CITY OF ALBUQUERQUE

Re: AT&T, 10036 Coors Blvd. NW
Request for Certificate of Occupancy- Transportation Development
Engineer's Stamp dated 3-25-16 (B13D014A)
Certification dated 5-22-17

Re: AT&T
10036 Coors Blvd. Bypass NW
30-Day Temporary Certificate of Occupancy- Transportation Development
Engineer's Stamp dated 3-25-16 (B13D014A)
Certification dated 5-22-17

C1.0

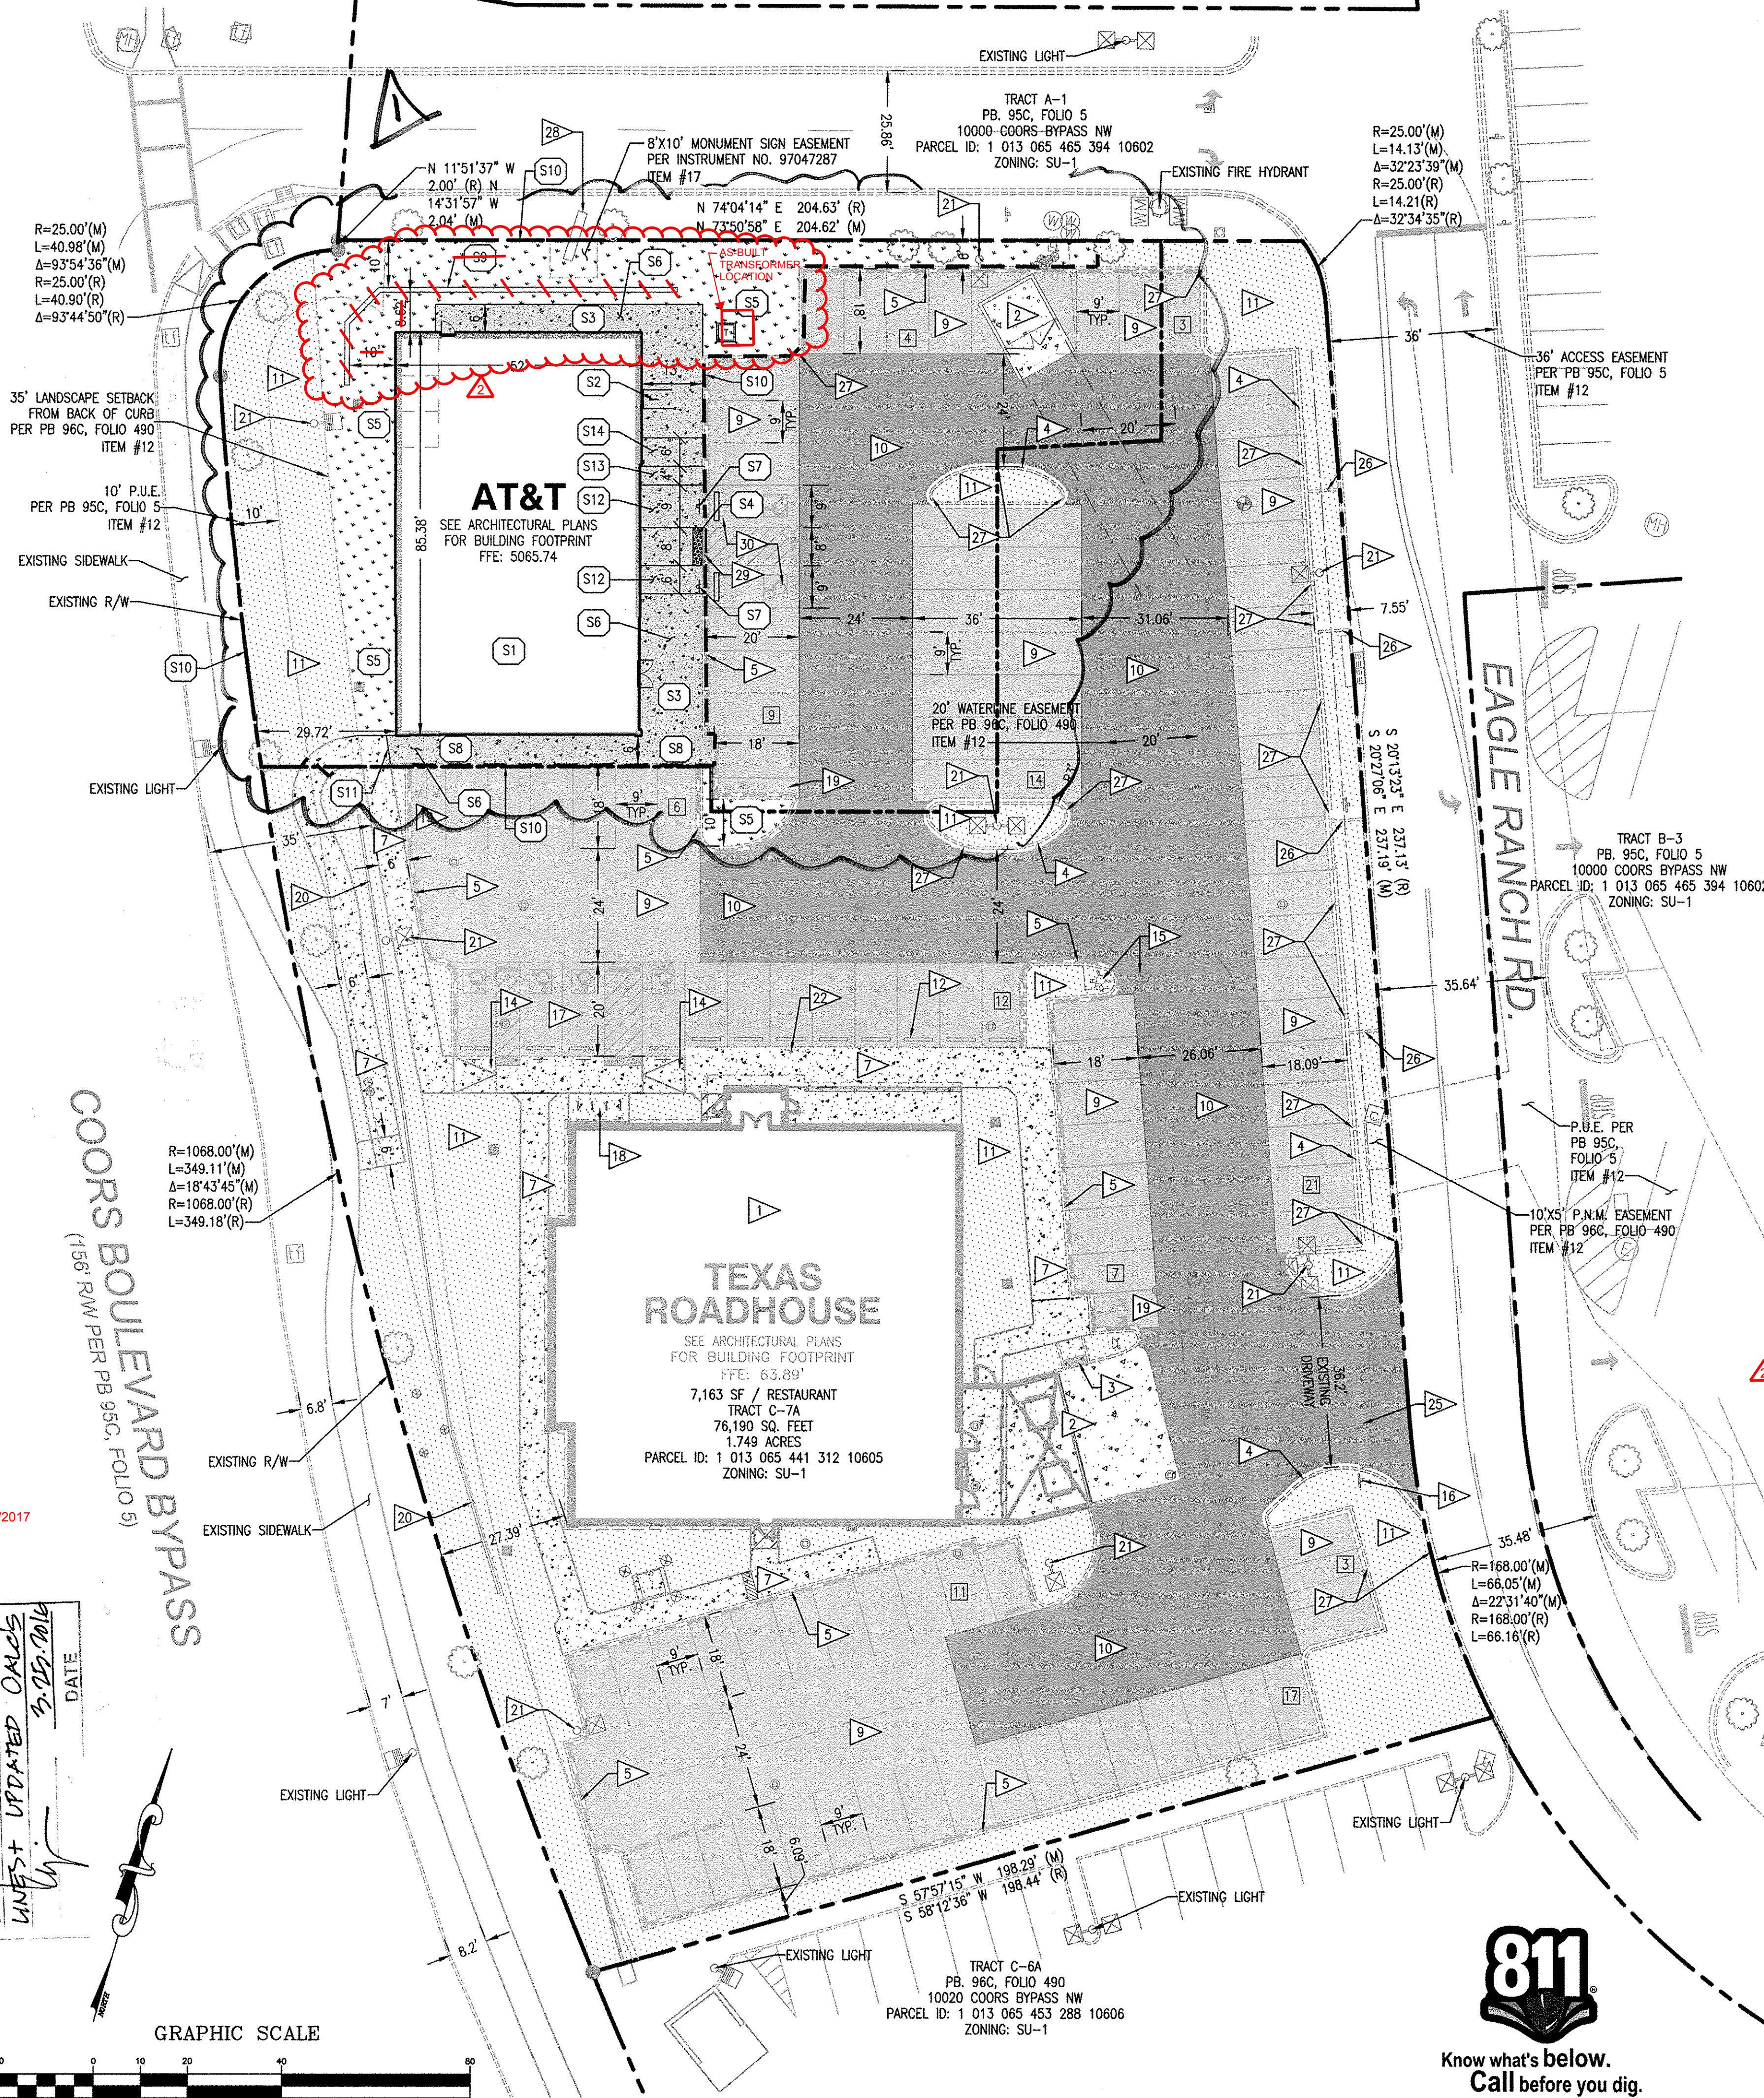
1. Add Motorcycle parking sign.
2. The ADA accessible parking sign must have the required language per 66-7-352.4C NMSA 1978 "Violators Are Subject to a Fine and/or Towing." Please call out detail and location of HC signs.
